Botley West Solar Farm

Schedule of Changes to the draft DCO

September 2025 (Change Request 2)

Document Ref: EN010147/APP/8.3 Rev 6

Legend	
Order Limit	
Areas Outside of Order Limits	
Features to be Removed	
Hedgerow to be Removed	
H3.01	55 m
H3.02	3.5 m

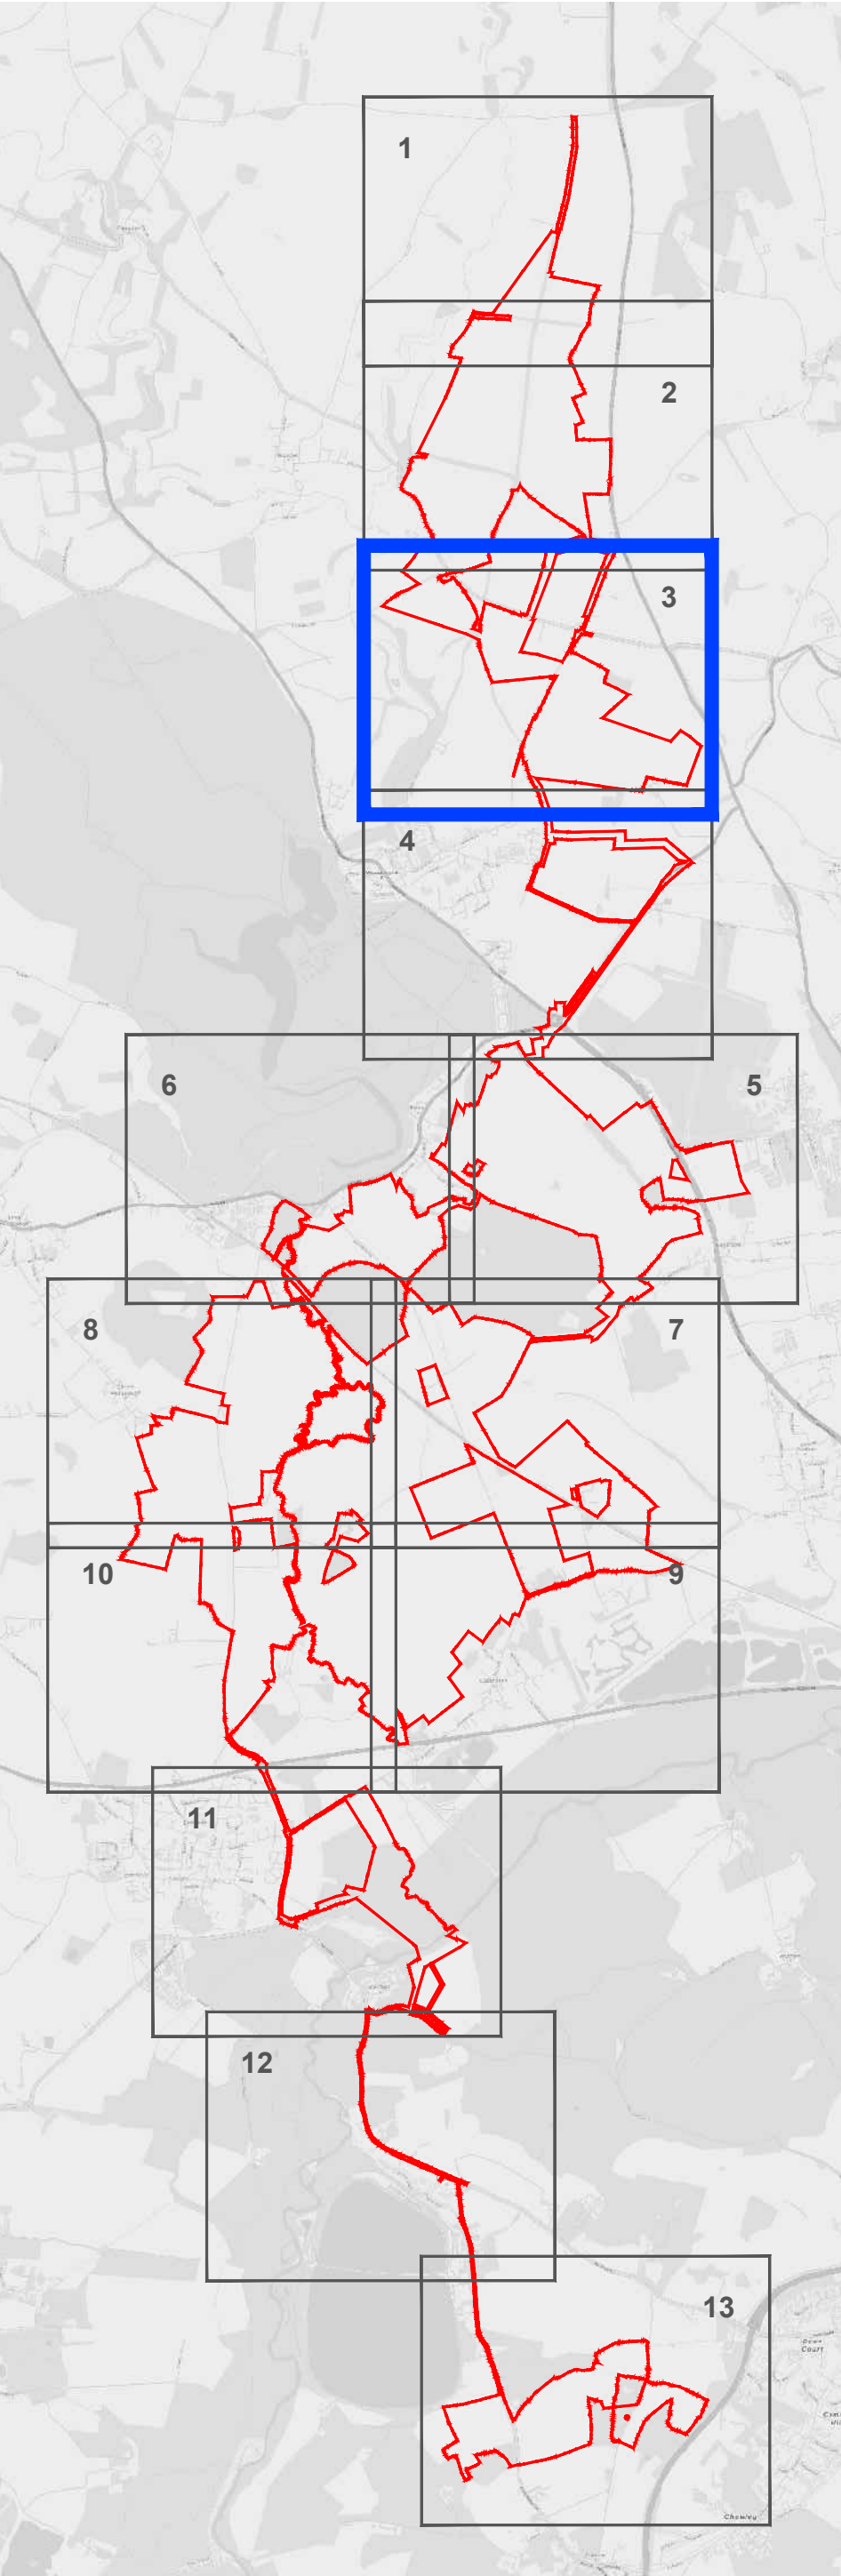
ARTICLE / PARAGRAPH	CHANGE	REASON FOR CHANGE	DEADLINE CHANGE WAS MADE AT
	<ul style="list-style-type: none"> “Removal of up to 55m of the hedgerow H3.01 within the Order limits as shown approximately within the Hedgerow removal plans Sheet 3 of 13.” “Removal of up to 29m of the hedgerow H3.07 within the Order limits as shown approximately within the Hedgerow removal plans Sheet 3 of 13.” 	<p>the DCO to facilitate that power. Notably, it is likely that most of the hedgerows identified will only be lowered for visibility splays and not removed entirely, therefore any practical limitations will be limited.</p> <p>The base mapping software used identifies that those four hedgerows areas are partially within the redline boundary and partially extend beyond the redline boundary. This mapping software may not be 100% reliable as the thickness of the hedgerows may depend on the season / growth of the vegetation, as well as the recent maintenance practices of the existing landowner(s), causing the thickness of the hedgerows to fall partially outside the redline boundary. This amendment therefore removes any doubt as to whether the DCO powers facilitate removal of the full width of hedgerows.</p>

H5.031.5 m

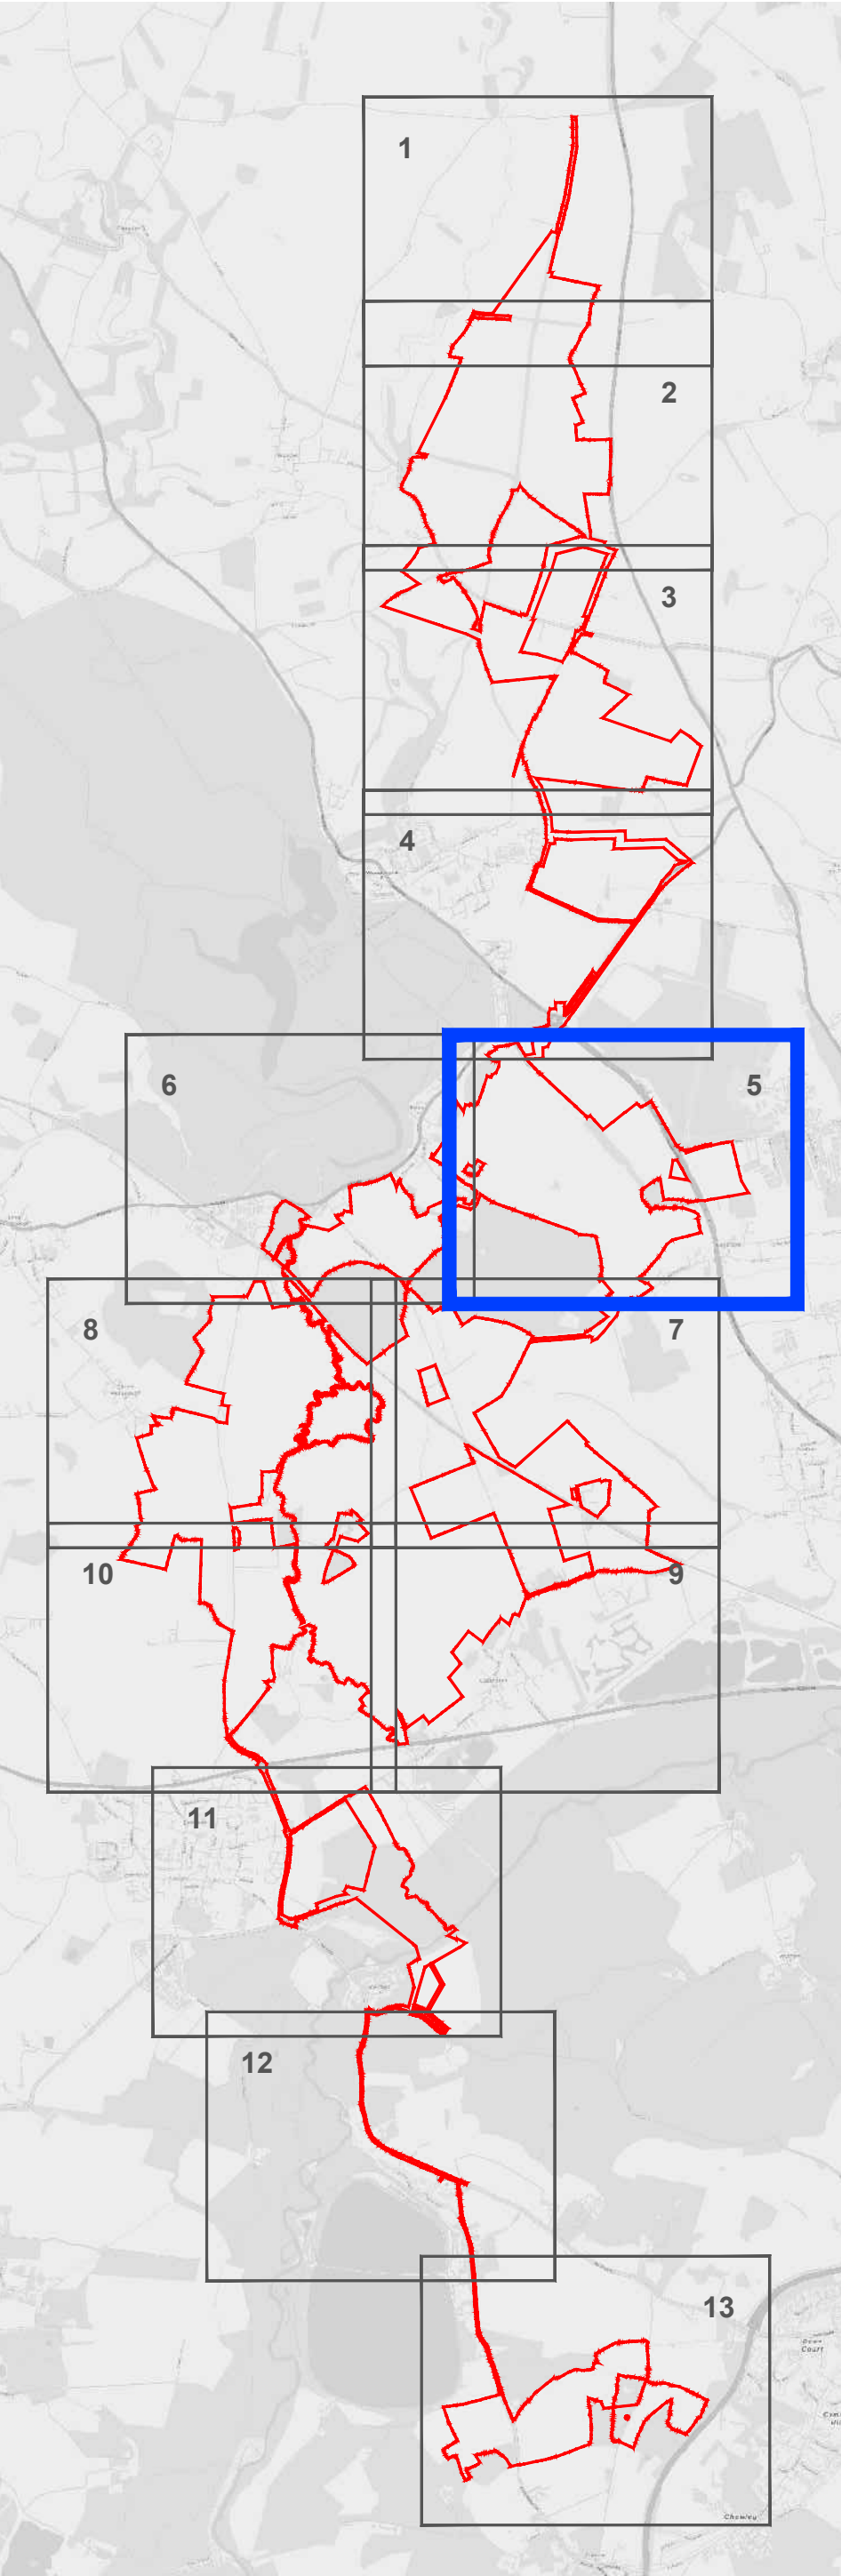
Deletion of the H5.03; H5.18; H5.19; H6.04 and H6.05.	Following Change Request 2 and consequential amendments to the Order Limits, the Applicant no longer	Change Request 2

ARTICLE / PARAGRAPH	CHANGE	REASON FOR CHANGE	DEADLINE CHANGE WAS MADE AT
		requires powers to remove these hedgerows. This is shown on the updated Hedgerow Removal Plans.	
	Insertion of H5.20.	Following Change Request 2 and consequential amendments to the Order Limits, the Applicant now requires powers to remove this hedgerows. This is shown on the updated Hedgerow Removal Plans.	Change Request 2
Schedule 13	Updates to document references, revision numbers and dates of latest documents.	General updates to reflect latest documents submitted alongside this Schedule of Changes.	Each deadline.
Schedule 15 (Part 5)	Removal of paragraph 4(1).	Consequential amendment as a result of the deletion of Article 12.	Change Request 2
Schedule 15 (Part 6)	Various updates.	Amendments to the protective provisions to reflect the agreed position with SGN.	Deadline 3
	Removal of paragraph 4(1).	Consequential amendment as a result of the deletion of Article 12.	Change Request 2
